Our Reference: NA231578
Your Reference: DOC25/401585

27 Aug 2025

**Re: SSD-73761707 Glendenning Road Data Centre – 2 Glendenning Road, Glendenning NSW
Response to Engineering Matters Raised by Conservation Programs, Heritage & Regulation
Group (CPHR)**

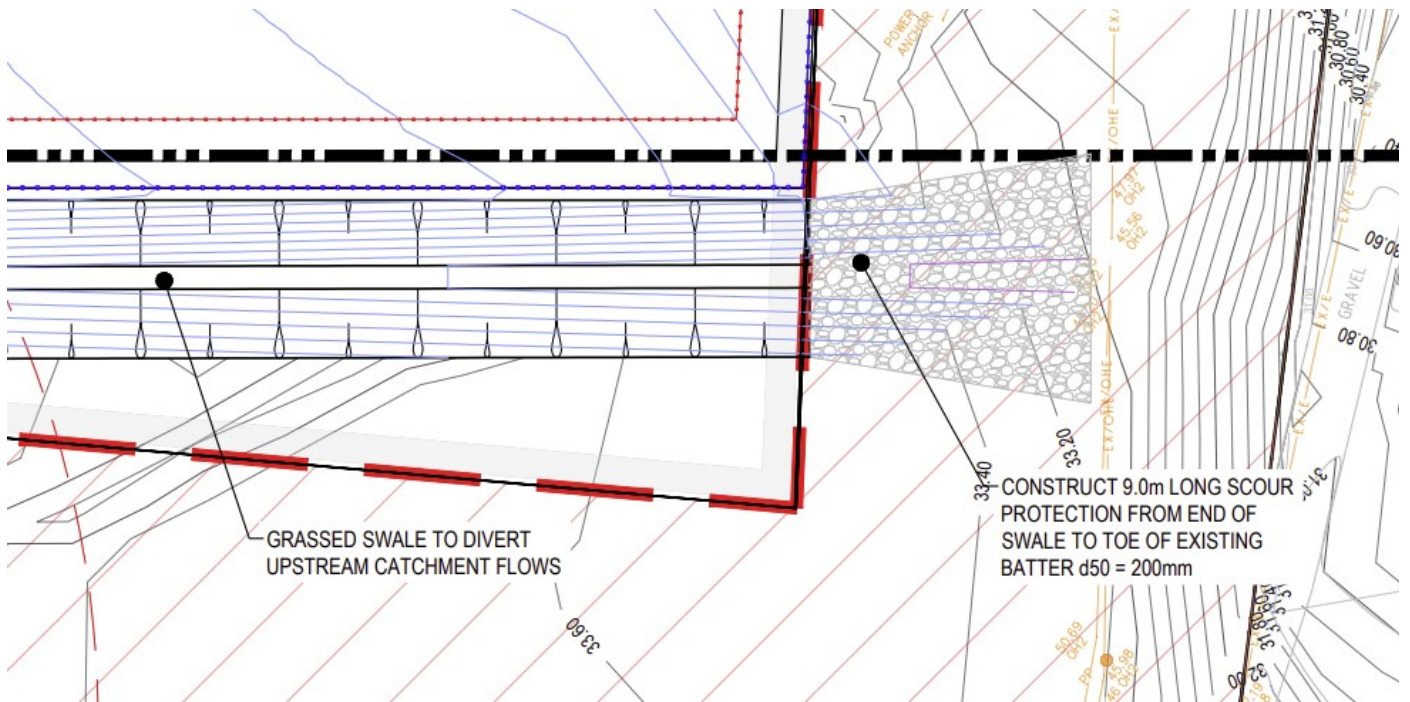
8. **Stormwater outlets – impacts** Two stormwater outlets are proposed along the eastern boundary. These outlets do not appear to connect into existing stormwater infrastructure or

waterway. Instead, they drain via a concentrated flow into the neighbouring land that is mapped on the [Biodiversity Values Map](#) and forms part of Nurragingy Reserve.
CPHR is concerned with the potential for erosion and pollution impacts over time past the proposed rock-armoured outlets, entering neighbouring land.
For the northeast outlet, there appears to be a nearby drainage channel that could be connected into. For the southeast outlet, no stormwater infrastructure appears to be nearby that could be used for a connection.

- Provide a solution for the south-east outlet, that minimises erosion.
- Consideration may be given to a combination of an absorption trench, level spreader and / or rainwater garden. The feasibility and suitability must be assessed by a suitably qualified stormwater engineer.

- how the adjoining land will effectively be protected from erosion
 - how the stormwater solution meets Blacktown Council's engineering guidelines and standard drawings.

The scour protection for the north-east stormwater outlet has been designed to reduce outflow velocity to less than 1.0 m/s in accordance with Blacktown Council requirements. This will protect the downstream environment from scouring and erosion.

The south-eastern drainage outlet is conveying overland flows from the southern upstream undeveloped land and Woodstock Avenue along the Endeavour Energy easement. The swale drain has been provided with scour protection to reduce flow velocity to acceptable levels (<1.0 m/s) to avoid scouring of existing pervious surfaces and the maintenance trail. This scour protection was discussed with Endeavour Energy as part of consultation to demonstrate negligible impact to their access route and infrastructure.

Figure 4-2 Existing conditions 1% AEP flood levels and depths (extracted from Blacktown City Council, 2016)

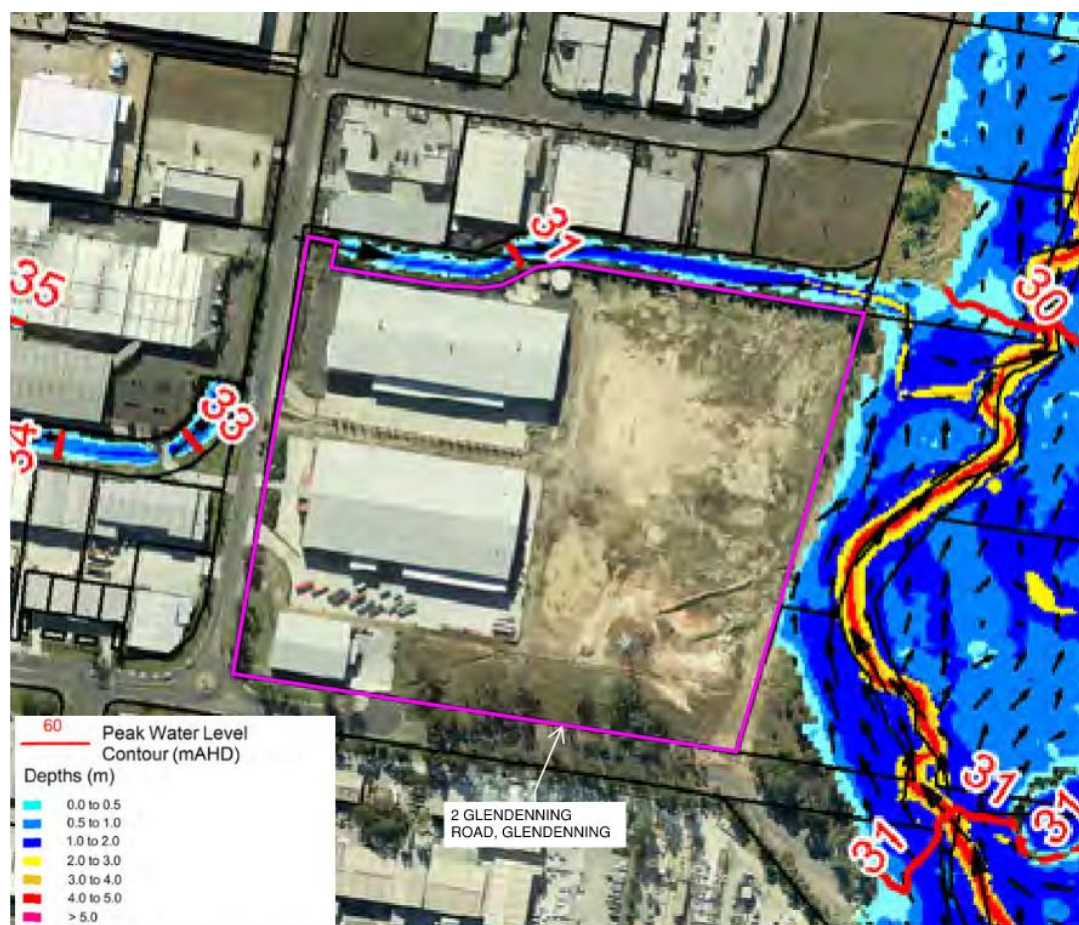
<p>1 <i>Flood Impact Assessment is not adequate</i></p>	<p>CPHR refers to Blacktown City Council's flood maps FloodBlacktown which shows the site is impacted by overland flooding in the 'Medium Risk Precinct' in the 1% Annual Exceedance Probability (AEP) event.</p>  <p>In addition, the site is impacted by Eastern Creek mainstream flooding in rarer flood events larger than the 0.2% AEP event. The depth of Eastern Creek flooding in the probable maximum flood (PMF) within the site ranges between 0.1 m to 0.4 m.</p> <p>The Flood Impact Assessment Report (FIA) is inadequate. The FIA includes discussion on existing flooding behaviour. However, no assessment for the post development scenario has been undertaken. No assessment for the impact of the development on flooding has been undertaken. No maps for existing, post development scenarios, or flood impact have been provided.</p> <p>Recommended action: The FIA is updated to assess the following:</p> <ul style="list-style-type: none"> consider the relevant provisions of the NSW Flood Risk Management Manual (2023) and associated guides, and Blacktown relevant Flood Studies for overland flooding and Eastern Creek address the full range of flood behaviour, flood constraints and risk for existing scenario for both overland flooding and mainstream flooding. To achieve this, flood behaviour would be examined for a range of events. Typical events examined may include the 10%, 5%, 1%, 0.5% or 0.2% AEP events and the PMF. The hydrological and hydraulic models developed by the consultant must be

<ul style="list-style-type: none"> compatible with the council's flood studies results for the full range of flooding address the full range of flood behaviour, flood constraints and risk for the post development scenarios for both overland flooding and mainstream flooding. To achieve this, the consultant must incorporate the development components onto the verified models and identify post-development flood characteristics for a range of events. Typical events examined may include the 10%, 5%, 1%, 0.5% or 0.2% AEP events and PMF identify the constraints that flood places on the land particularly hydraulic constraints that is flow paths, flood storage and flood hazard, determined for several events, typically 5%, 1%, 0.2% or 0.5% AEP and PMF assess the appropriateness of the development or development types for the location based on the flood constraints on the land identify the impacts of the development on flooding and on adjacent areas for the full range of flood events identify and assess the adequacy of management measures and development controls to: <ul style="list-style-type: none"> effectively address these constraints to ensure the flood risks to the proposed development and its users are acceptable, manage flood and associated emergency management (EM) impacts to the existing community due to the development and outline how the development has considered climate change impacts on flooding behaviour.

Review of flood data in the Local Overland Flow Path Study within Existing Urban Areas of Blacktown City Final Report indicates that overland flow in Glendenning Road adjacent to the site does not exceed 0.2 m deep, and assessed not to overtop the road and enter the site in the 5% AEP, 2% AEP or 1% AEP overland flow events. This is supported by flood mapping (Eastern Creek Catchment Development Scenario Hydraulic Assessment (Blacktown City Council, 2016)) that shows 1% AEP and 0.2% AEP flood events do not directly impact the site. This assessment is also supported by Figure E1.5 in Local Overland Flow Path Study within Existing Urban Areas of Blacktown City Final Report. In these events, flood water is contained within the drainage channel to the north of the lot and in Eastern Creek (external to the lot) to the east. The proposed fill will therefore not cause an increase in flood levels on site or neighbouring properties or public areas for the medium risk overland flow event (1% AEP).

A meeting with Blacktown City Council to assess flood impact comments from Council’s Engineering department was held on 18 August 2025. It is noted that Council’s concerns related to the portion of the site inundated by the 1% AEP flood event adjacent to the Endeavour Energy transmission tower, described as the “medium flood risk precinct”. The area of concern is shown in Figure 1 below.

Furthermore, we note that the site will be re-graded to remove the above isolated sag points in the topography, effectively also removing the 1% AEP extent of inundation to the site. Figure 3 below shows the post-development re-grading, swale drain and site stormwater system.
